**Re: AutoZone #9260 at 9510 Universe Blvd. NW  
Erosion and Sediment Control Plan  
Engineer's Stamp Date 12/10/24 (B10E003C3A)**

Based on the information in your submittal, received on 12/12/24, the ESC Plan can't be approved until the following comments are addressed.

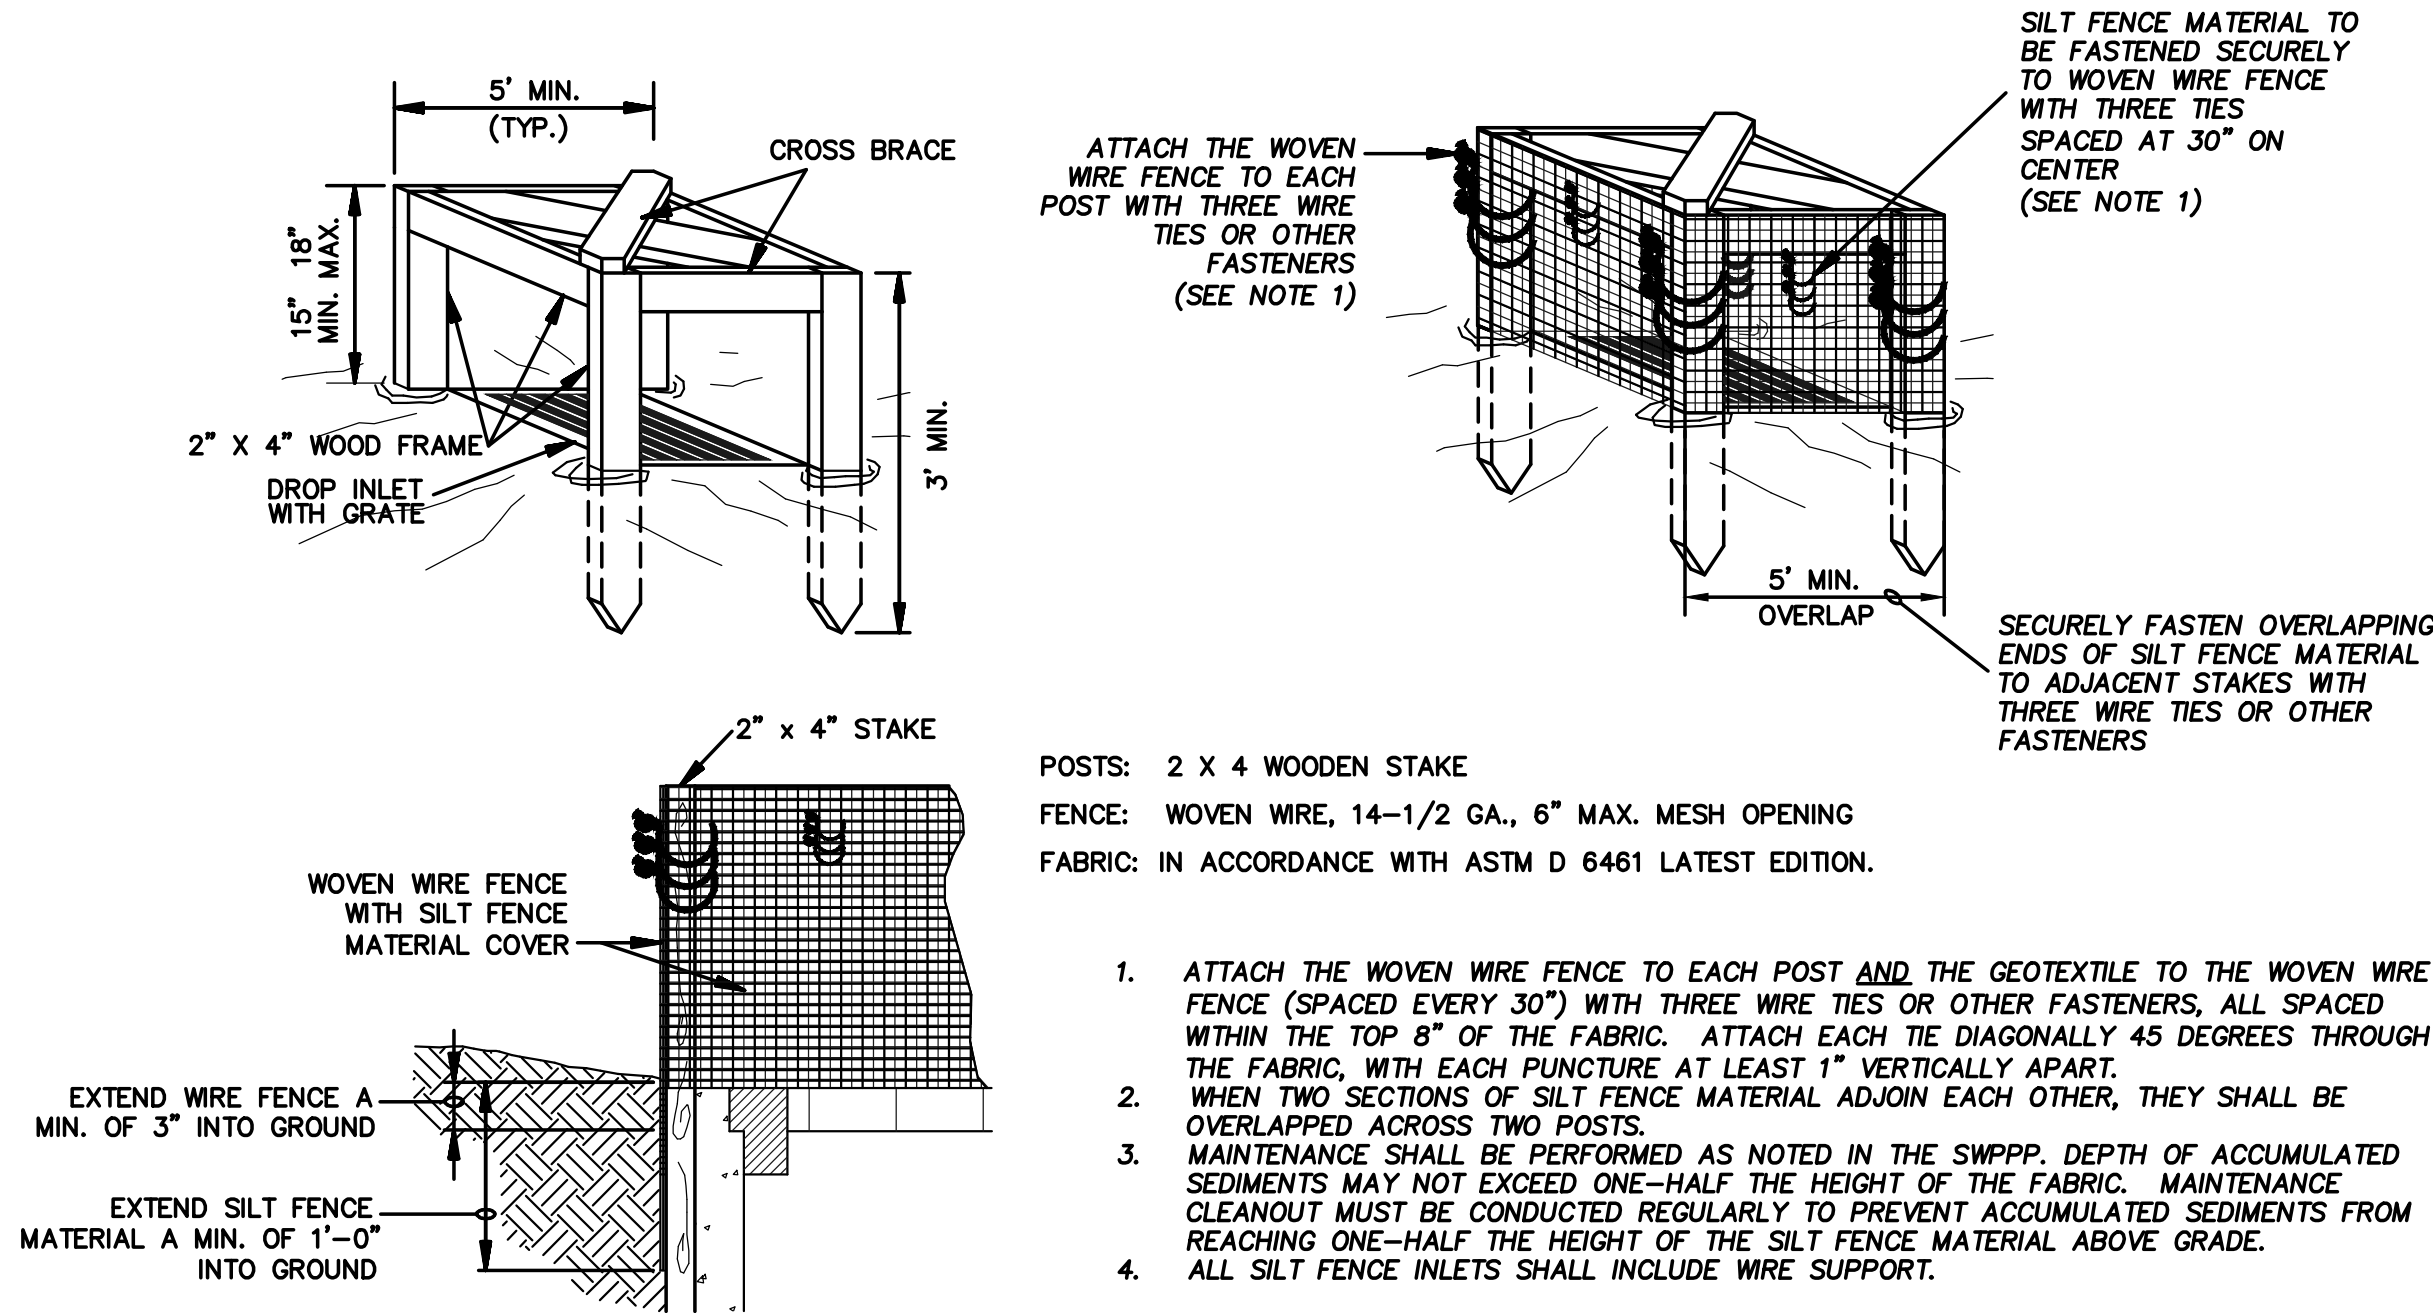
3. The location of the area of "Construction Support Activities" must be shown on the ESC Plan. If it is located offsite, the offsite property owner's NOI is required, and stabilization specifications must be included in the ESC Plan.

5. The Construction Exit (CE) is located in one of the two locations where concentrated flow enters this site. Basin B is a 2.57-acre offsite area, 90% impervious, contributing about 8400 cf of stormwater during the 2-yr 24-hr storm that enters the site at the northwest corner. That corner of the site will be muddy every time it rains until a lined conveyance system is constructed. Please consider moving the CE out of the concentrated flow path. Also, consider constructing a stabilized flow path through the site earlier in the construction sequence.

6. Please add a note stating that the sediment trap can be removed after stabilization of the flow path from the northwest to the southeast corner of the site. Concentrated flows entering the site's northeast corner are relatively minor since Basin A is mostly undeveloped, so a silt fence should be sufficient there.
